<b>Application Ref:</b>	3/2026/0307	 Ribble Valley Borough Council <a href="http://www.ribblevalley.gov.uk">www.ribblevalley.gov.uk</a>	
<b>Date Inspected:</b>	N/A		
<b>Officer:</b>	BT		
<b>DELEGATED ITEM FILE REPORT:</b>		<b>Decision</b>	<b>REFUSAL</b>

<b>Development Description:</b>	Prior notification for proposed agricultural building under Part 6 Class A of the GDPO.
<b>Site Address/Location:</b>	Fells Farm, Wigglesworth Road, Slaidburn, BD23 4SY.

Project Name	Project No.	Stage
Fells Farm	137.21	Planning Submission
Proposed Elevations 03	Scale Date	1:100 @ A1 April 2020
Rev A	Drawn	RP

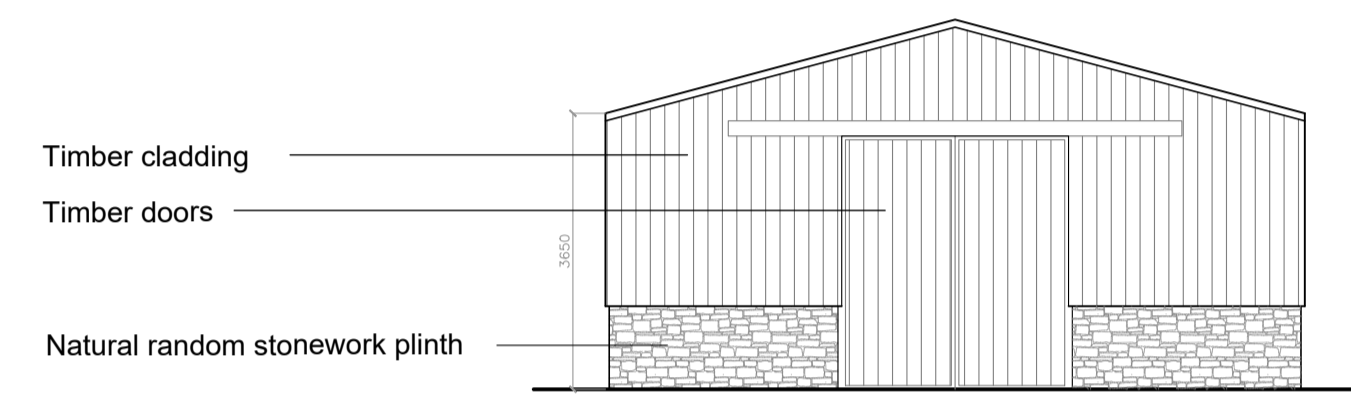
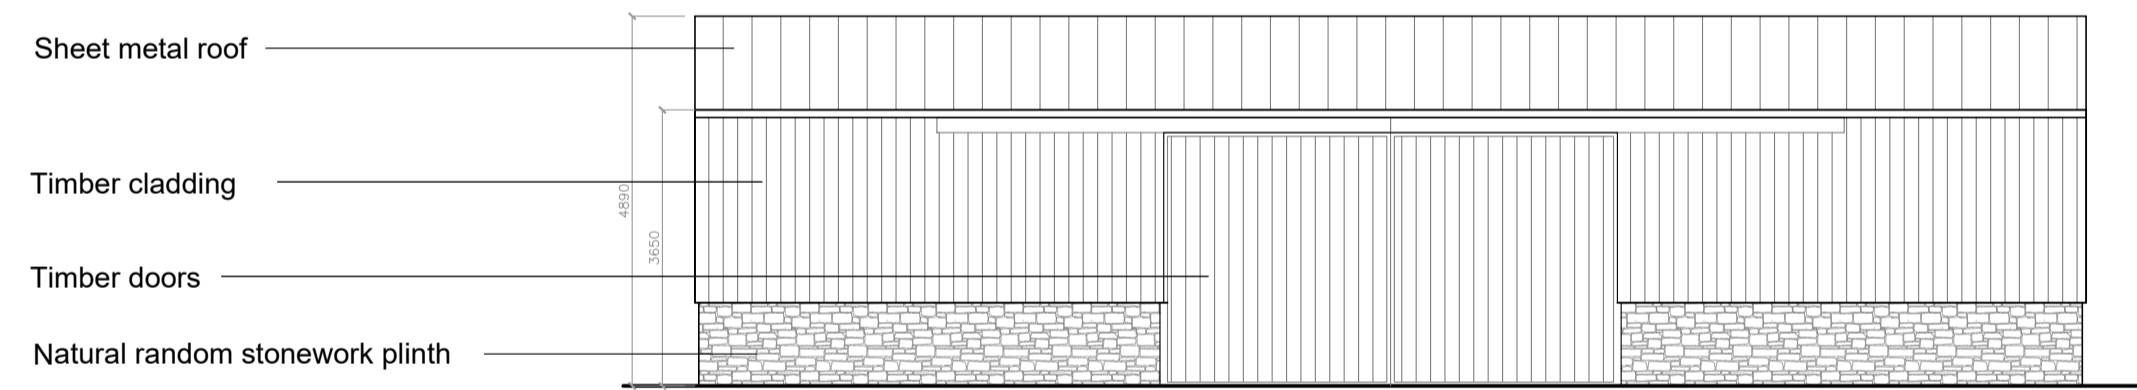
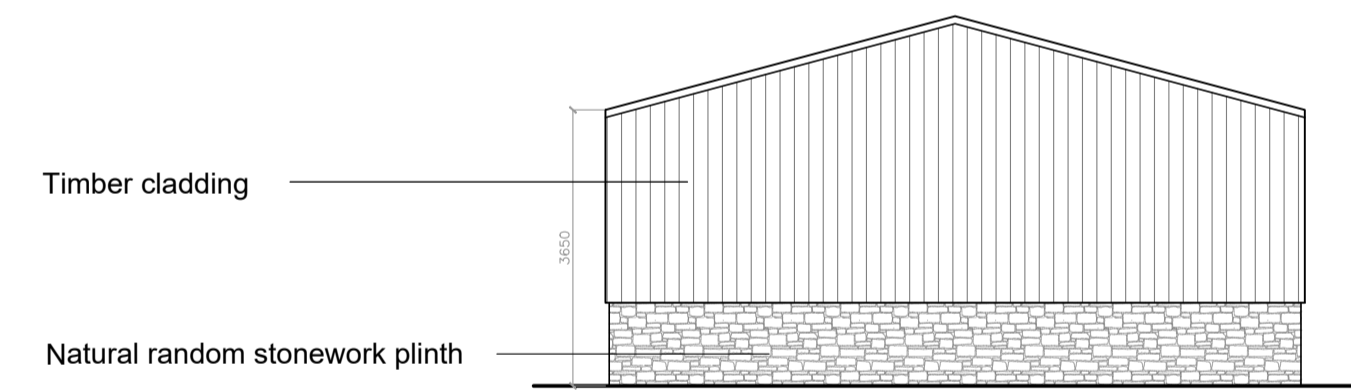
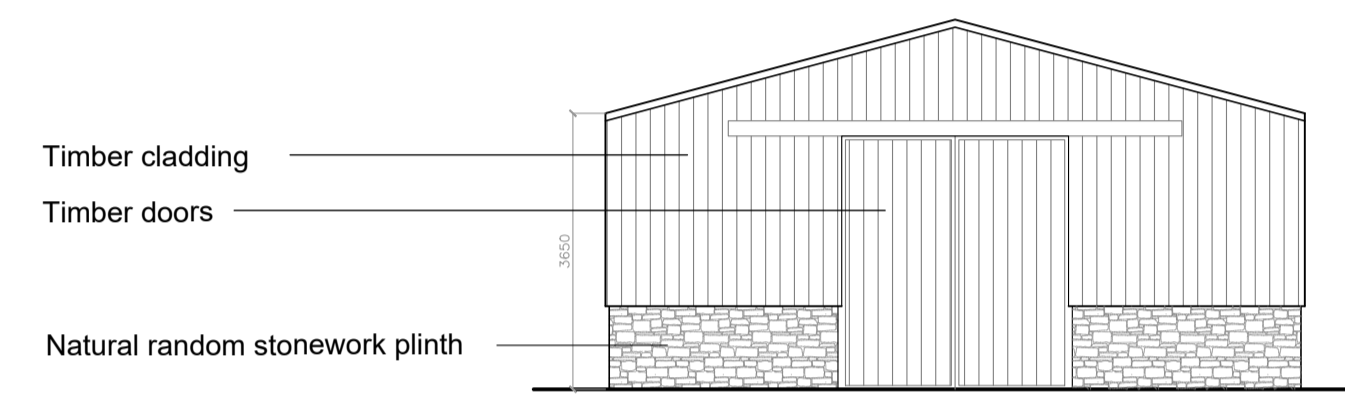
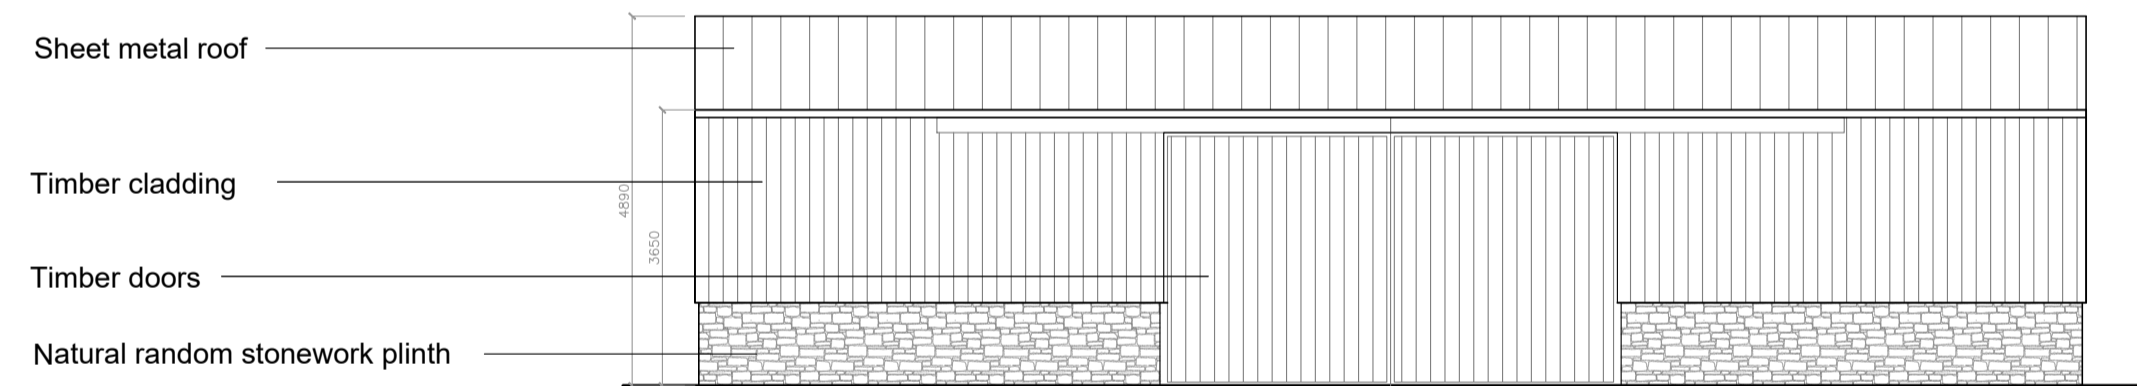
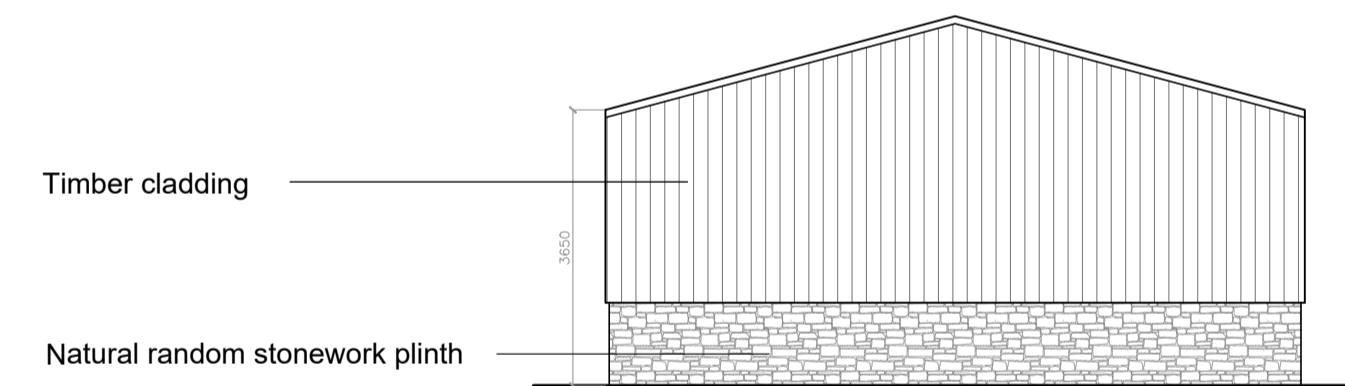
The proposed building would comprise a portal framed design detailed with a stone plinth, timber cladding, timber doors and metalised roof sheets, all of which are materials commonly used in the construction of modern agricultural buildings. As such, the external appearance of the proposed building would be in keeping with the rural vernacular of agricultural buildings within the locality. In addition, the proposed building would comprise a similar size to the adjacent barn building with respect to its footprint which in this instance is considered to be proportionate in relation to the quantity of farm machinery and associated equipment that it would accommodate. In addition, the proposed building would be a modestly sized structure with respect to its height. As such, the proposed building would not read as an over dominant addition to the application site. Solar panels are proposed for the Southern roof slope of the building and whilst it is acknowledged that these would not be wholly in keeping with the rural setting of the site, the originally proposed quantity of solar panels has since been reduced to a level which is now

considered to be acceptable. Consequently, it is not considered that the proposed development would be harmful to the visual amenities of the immediate area or wider landscape.
